STATE OF NORTH CAROLINA
DEPARTMENT OF TRANSPORTATION

May 8, 2013

Subject: **Response to On Hold Letter** for request for Section 401 Water Quality Certification Modification, Wilmington Bypass from north of US 74/76 in Brunswick County to US 421 in New Hanover County. DWQ Project No. 10-0867v.4. TIP R-2633B.

Reference: NCDOT Modification Request, dated April 3, 2013
NCDWQ On Hold Letter, dated April 19, 2013, received April 26, 2013

PERMIT DRAWING
SHEET 28 OF 73
REVISED: 1/20/2015

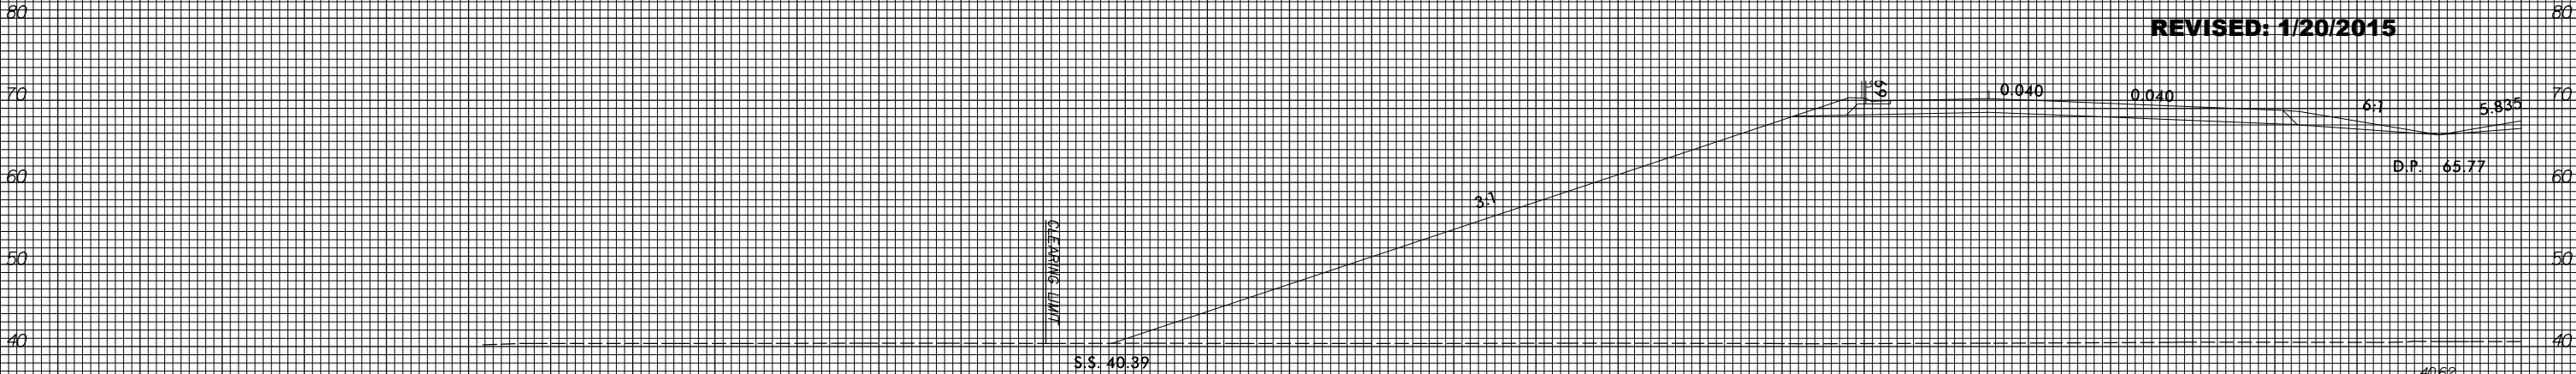
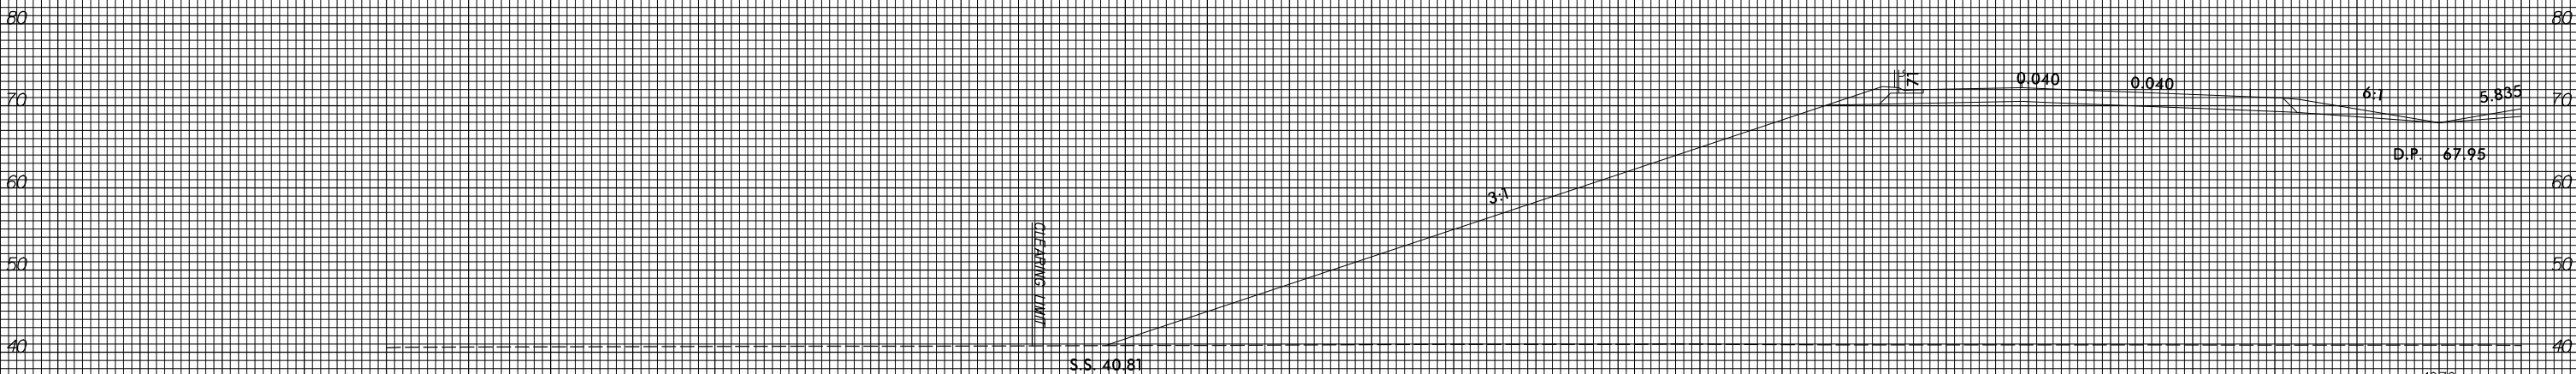
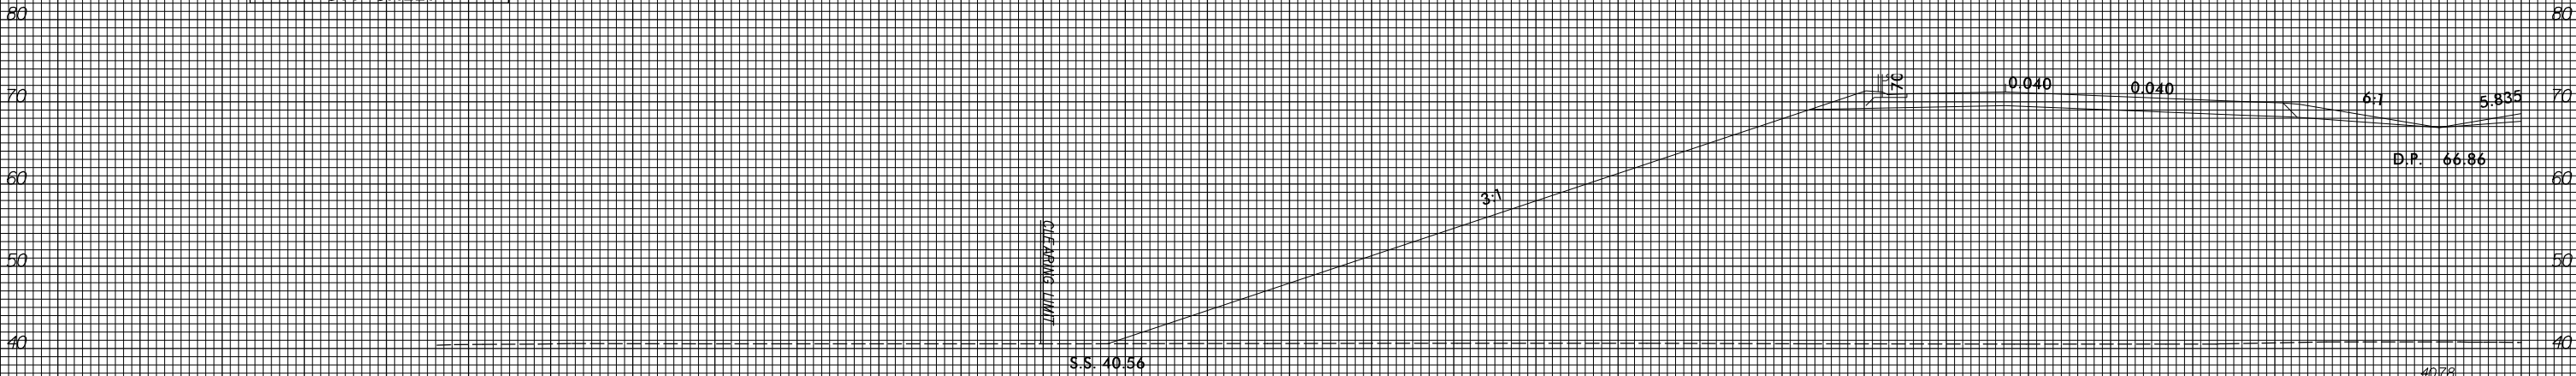
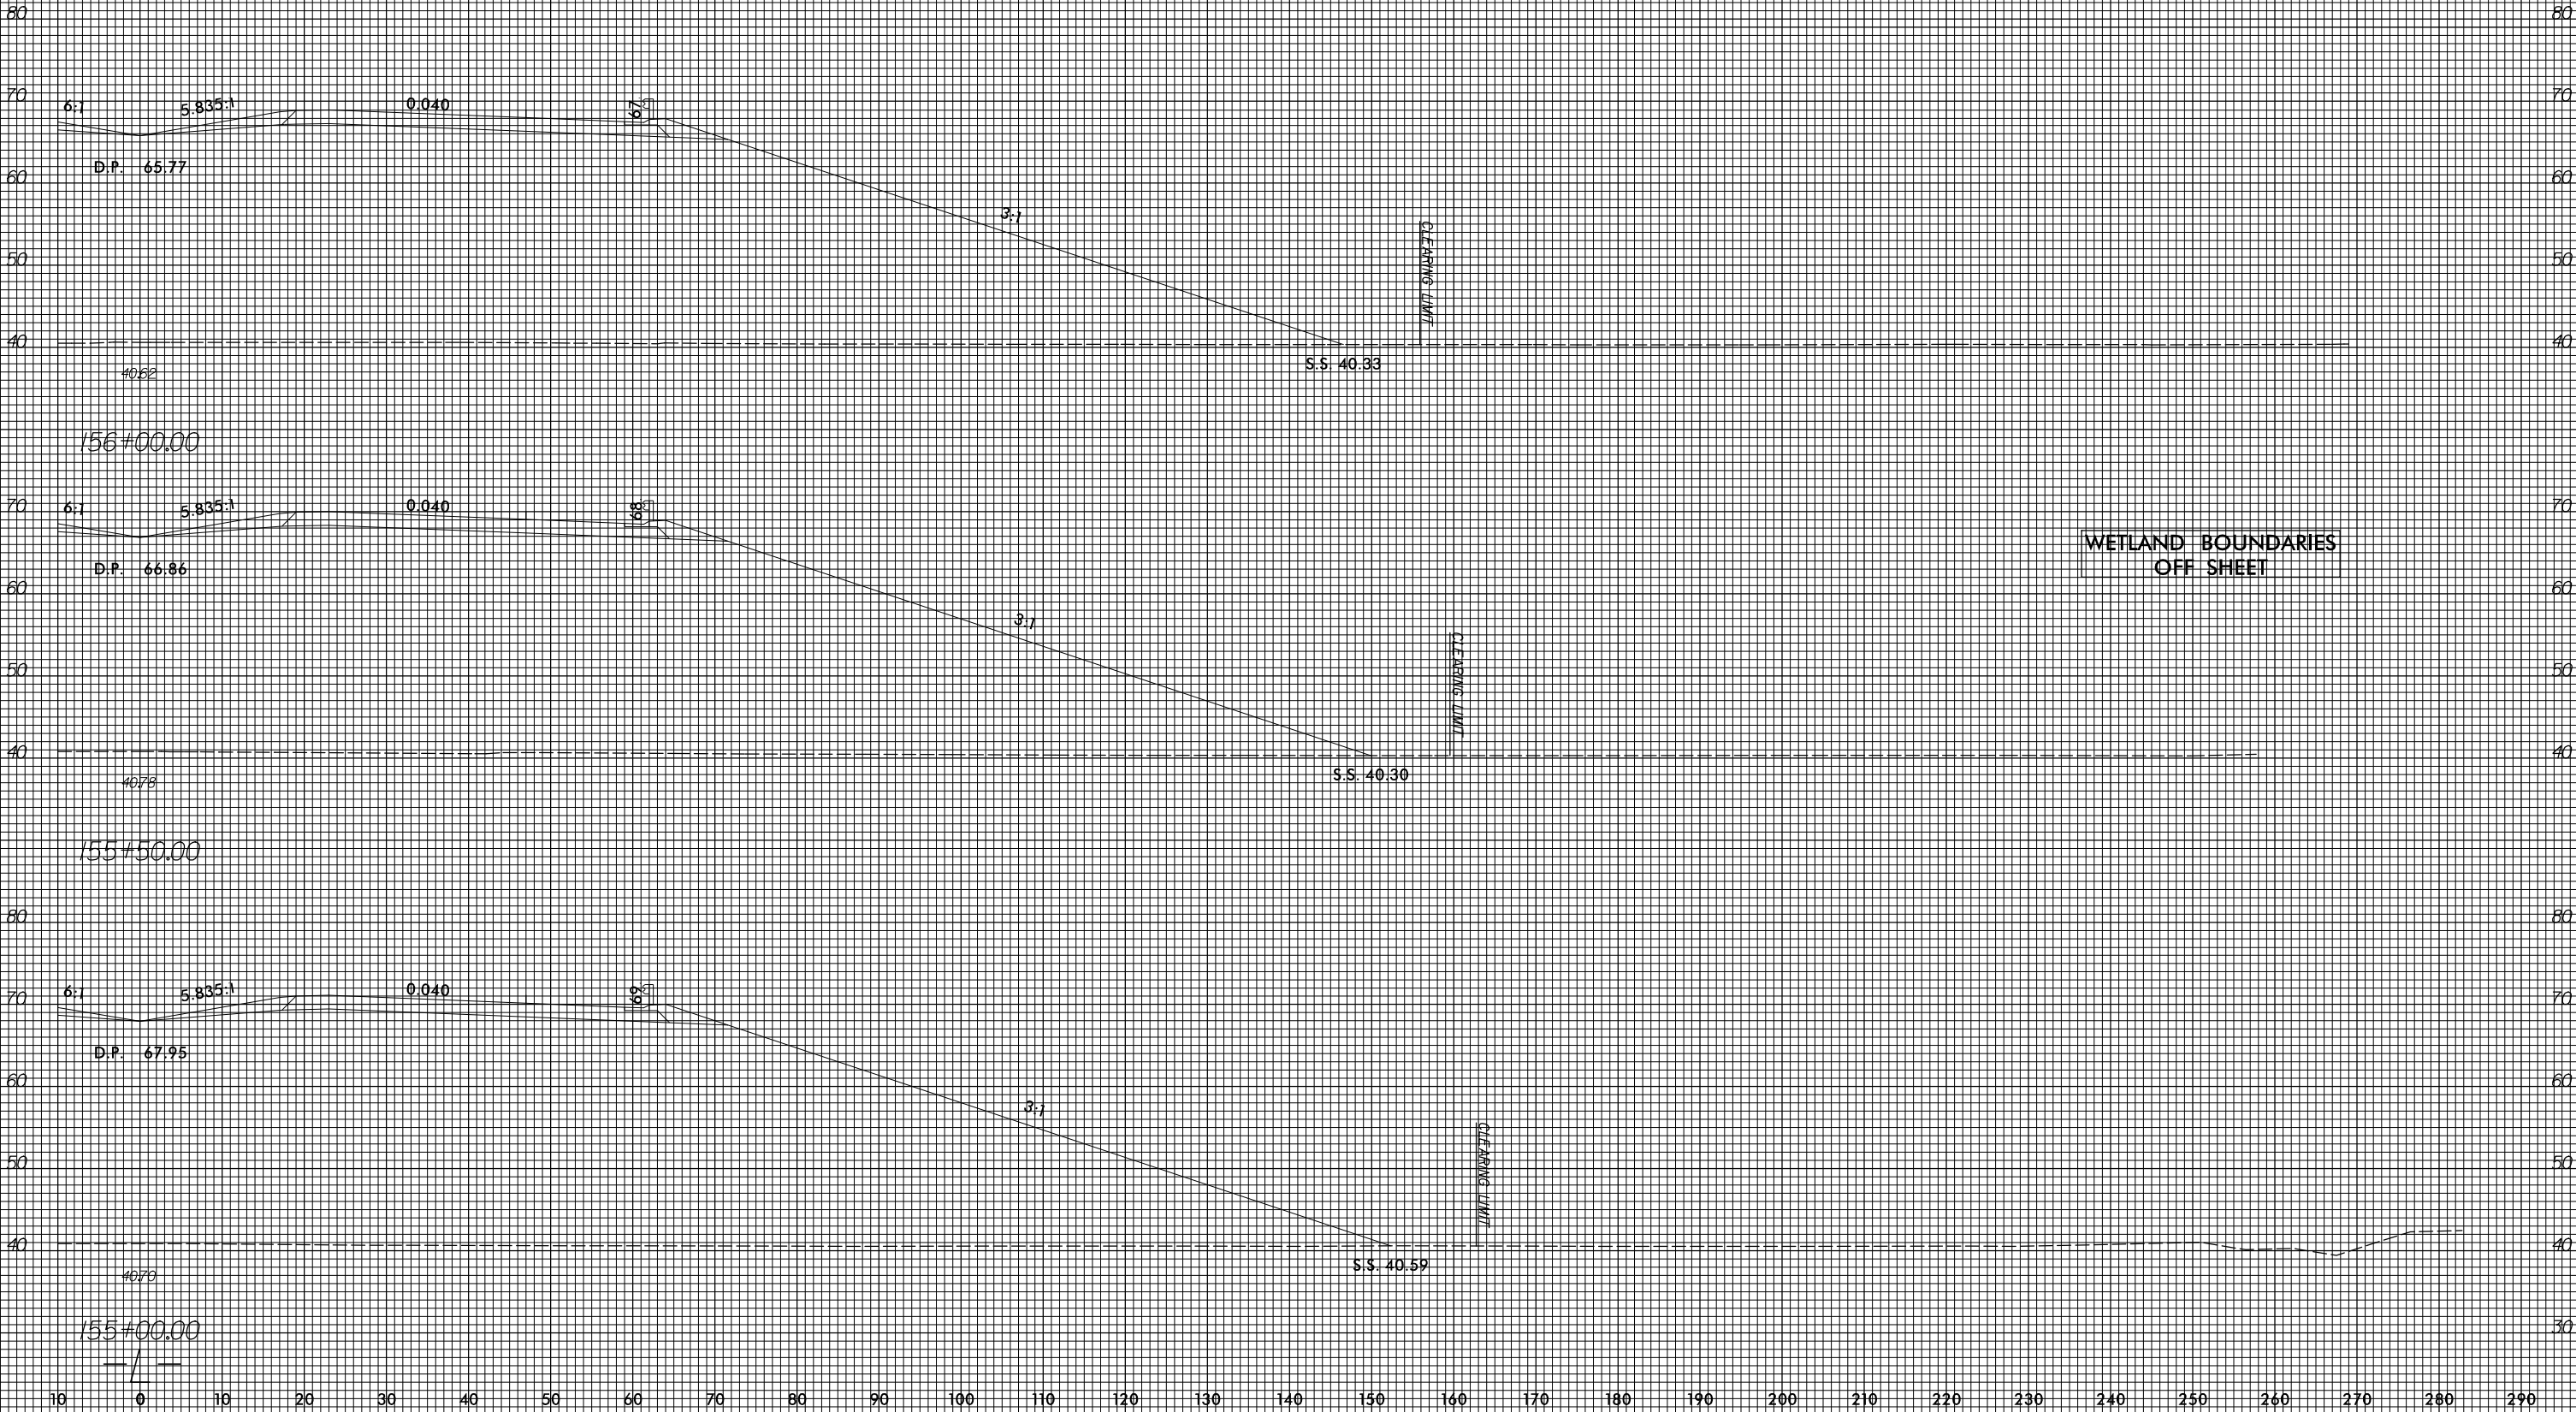
4. *Site 7 (permit drawings 27/28), a wetland boundary limit is shown on the cross sections beyond the clearing limits however the plan sheets show that the entire right of way is within the wetland. Please clarify.*

4. Site 7 (permit drawings 27 /28), a wetland boundary limit is shown on the cross sections beyond the clearing limits however the plan sheets show that the entire right of way is within the wetland. Please clarify.

The wetland boundary limits are outside of the fill slopes. A note has been added to the cross sections. Revised sheets for Site 7 (Permit drawings 27 and 28) are enclosed.
